Your Ref: OWPC19487
Our Ref: AB/64/18/HH
Please ask for:
Mr Z Denton

6th August 2018

Single storey rear extension with balcony at first floor level.
16 Dalloway Road Arundel

drawing
Typical Cross Section and Elevations
As Proposed

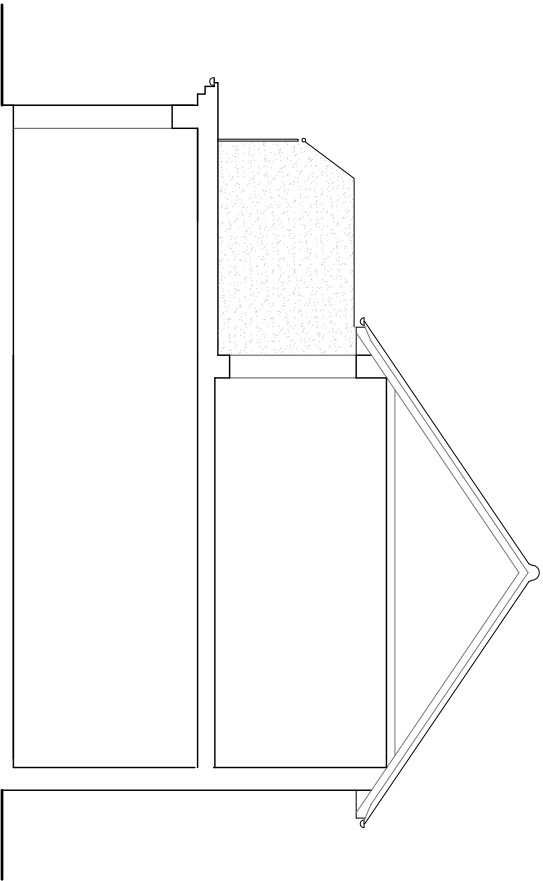
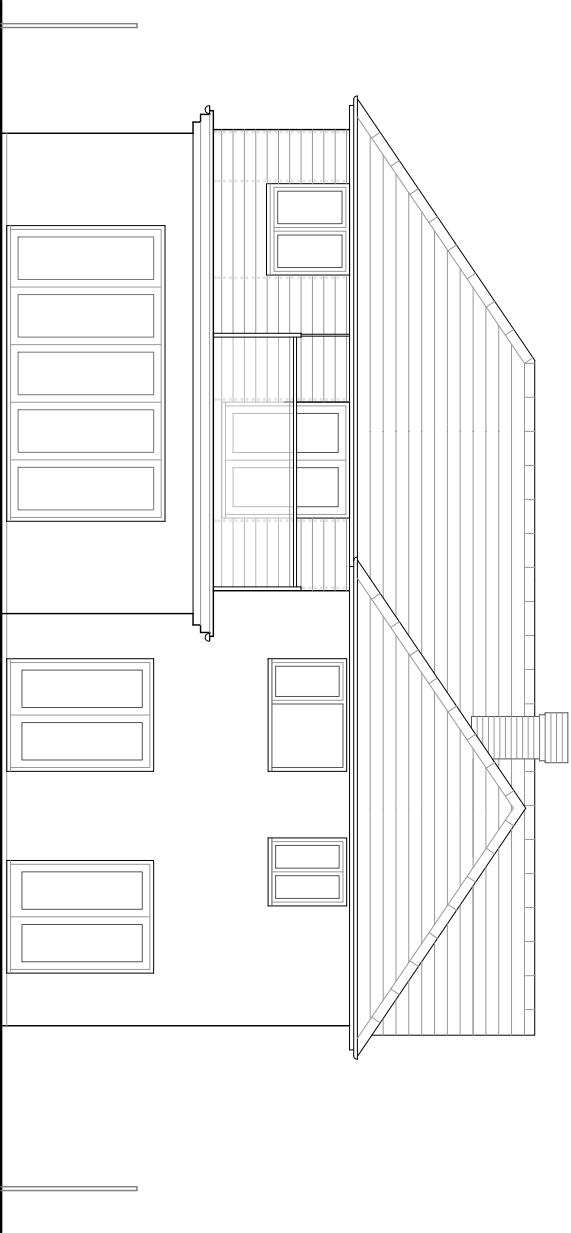
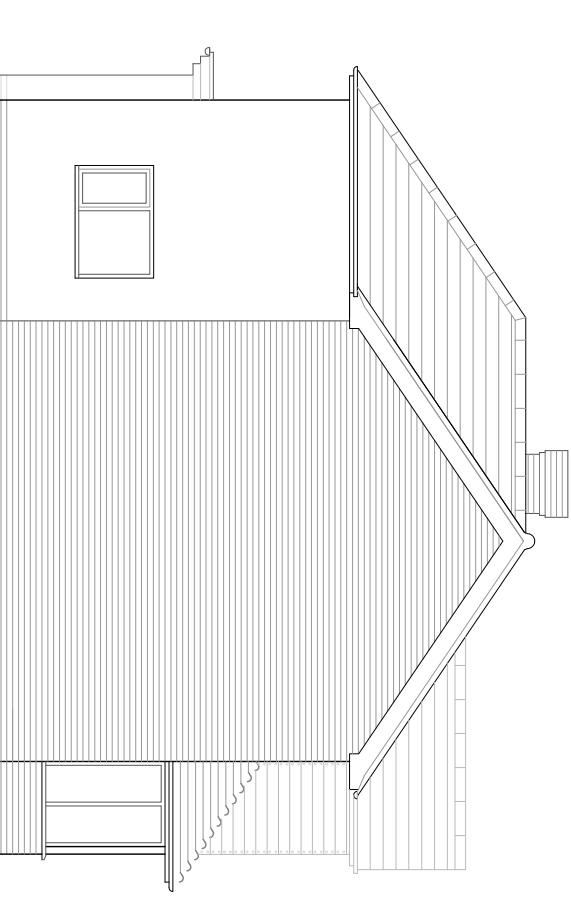
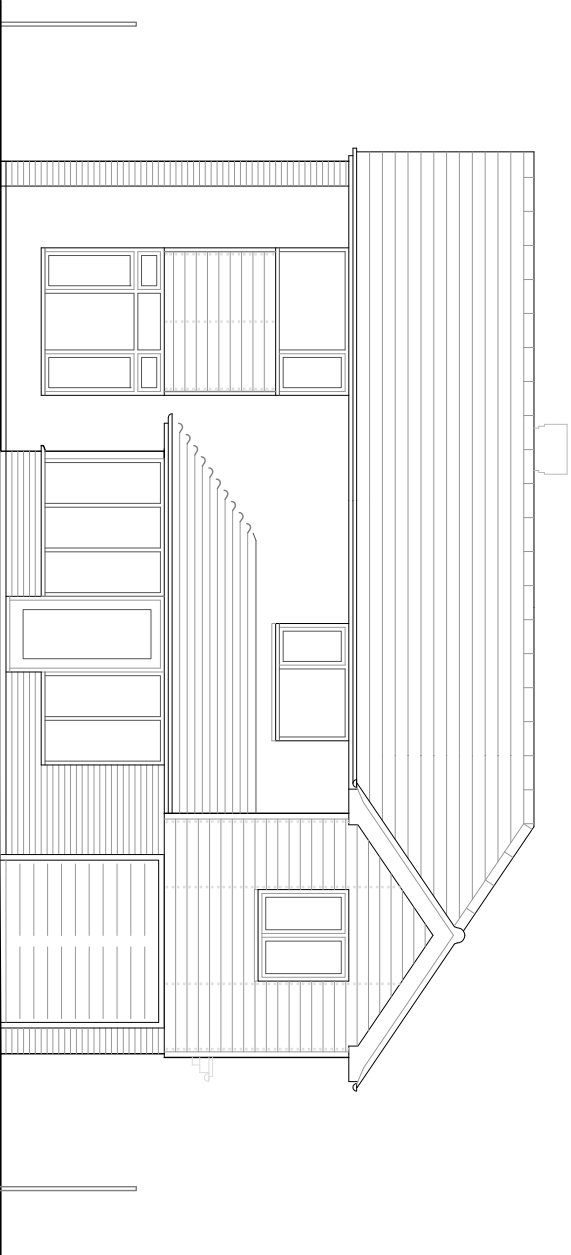
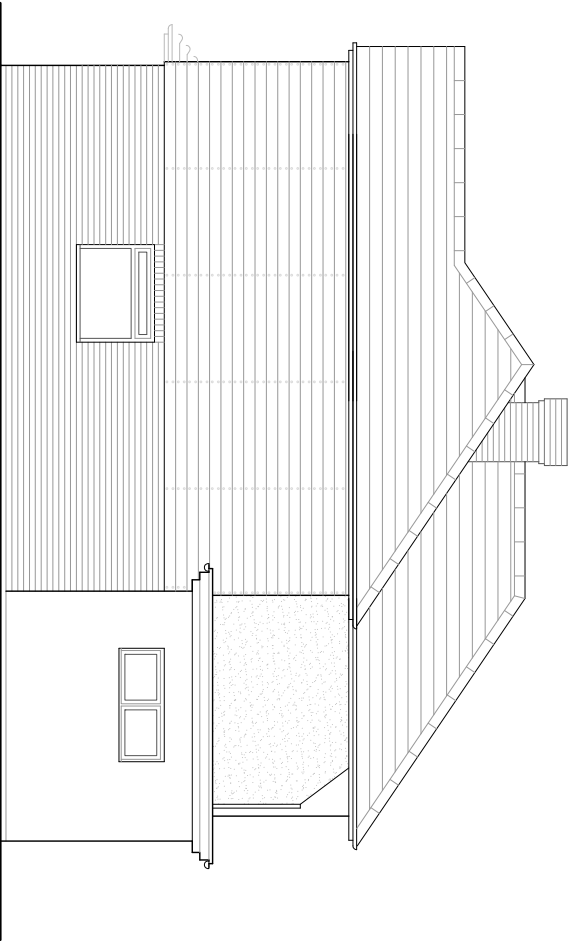
The Committee had no objection to the application subject to the imposition of a condition specifying that the side panel(s) should be constructed of obscure glass only and shall thereafter be permanently retained with obscure glass only.
